Application: SSI 7485

I write regarding the proposed modification to M4-M5 Link, Mod 2 The Crescent overpass and changes to pedestrian infrastructure in North Annandale, Rozelle and Rozelle Bay Foreshore area.

Figure 4-2 Pedestrian and cyclist bridge infrastructure options

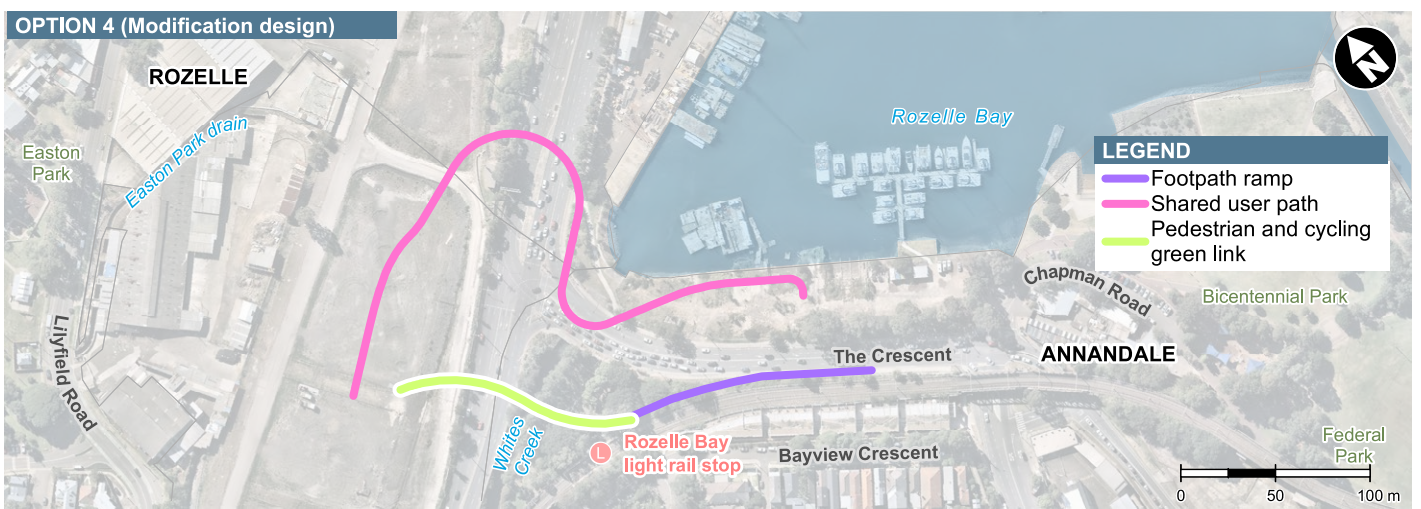
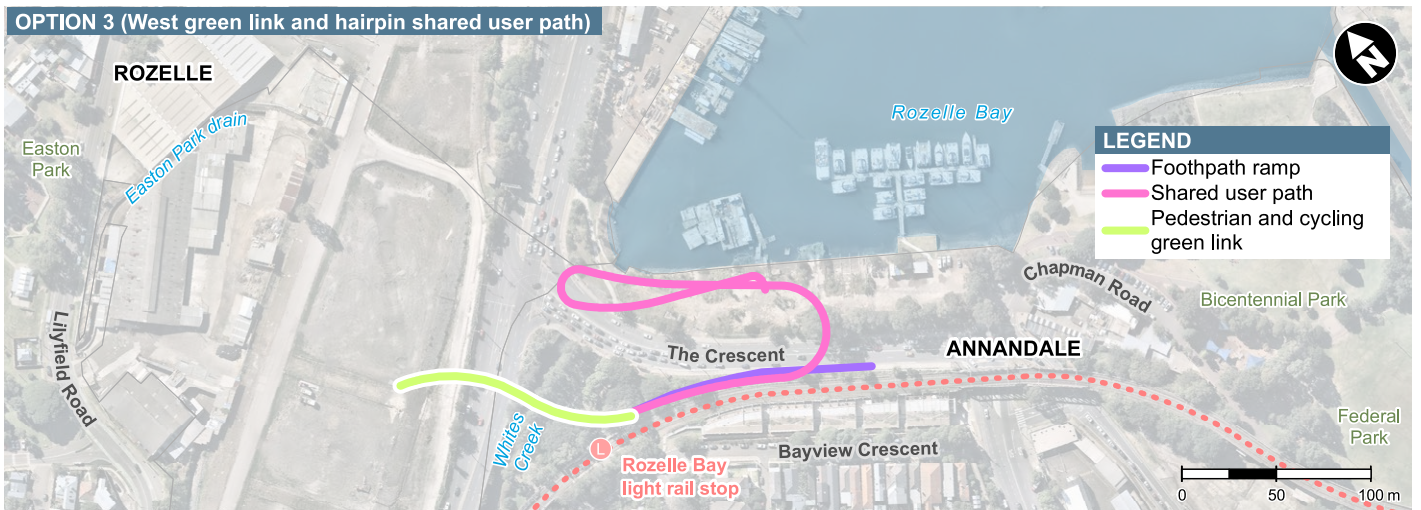
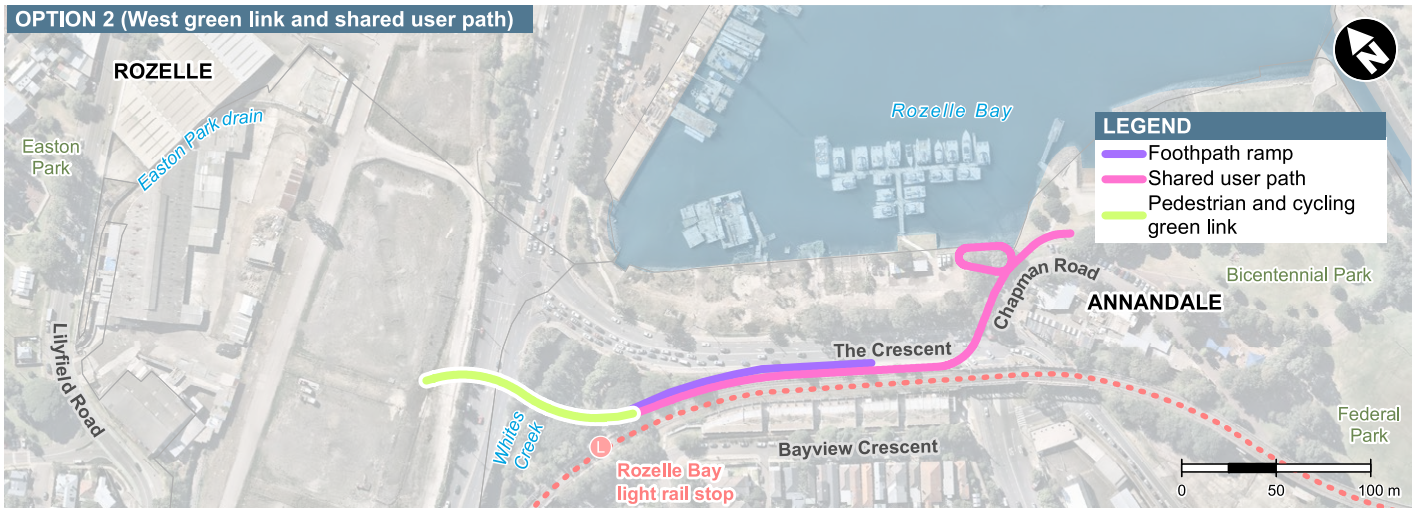
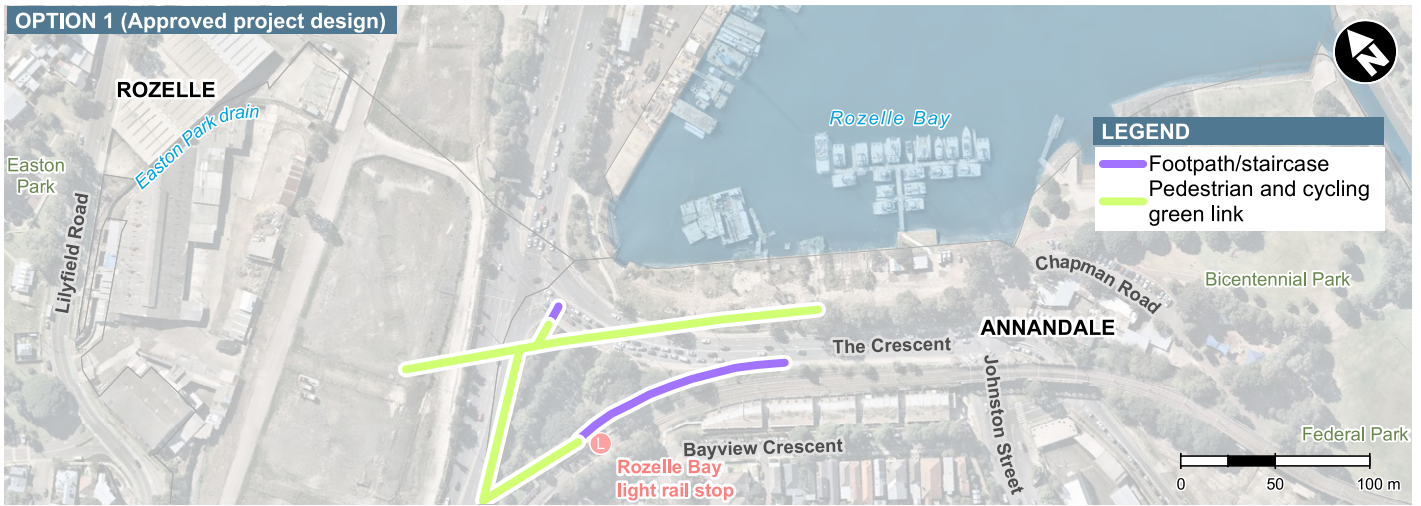
I request RMS work with the community to explore alternate design options to the proposed new car overpass design and the changed pedestrian and cyclist links. I am seeking the reinstatement of the safe, direct access from the approved EIS GreenLink to create a continuous green open space connection from the Rozelle Rail yards and Annandale to the foreshore. The GreenLink was more than just a walk way - it put people central to the design, maximising safety, and providing much needed accessible open space for the community now and into the future Bays Precinct design.

- The significantly reduced safety and increased risk for pedestrians and cyclists with removed access over The Crescent to Bicentennial Park and the increased traffic along Johnson Street.
- Being required to cross five sets of pedestrian lights at The Crescent as my option to reach the foreshore from Annandale or from Rozelle Bay light rail stop.
- Removal of direct active links to the foreshore, cutting the community off from the area and the proposed revitalisation of the entire Bays Precinct, including linking the Light Rail and Bus stops to a Ferry wharf and Metro station.
- Urban and landscape design that is being built before a finalised Masterplan for the area.
- Traffic changes that limit movements around the suburb and create further congestion in the local streets of Annandale, Forest Lodge, Glebe, Lilyfield and Rozelle with no planning to deal with these.

- Reinstate the GreenLink connecting communities and green open space from Rozelle to Bicentennial Park
- Relocate and design pedestrian and cyclist connections that are continuous, safe and direct.
- Design the modification infrastructure and active links in response to the character of the suburbs, the location of the foreshore and its potential future development.
- Provide pedestrian and cyclist paths that maximise people safety and do not force them onto busier streets, unsafe concrete plazas and caged walkways.
- Integrate active and direct connections to all active transport – including the future Metro West and Foreshore Ferry Wharf
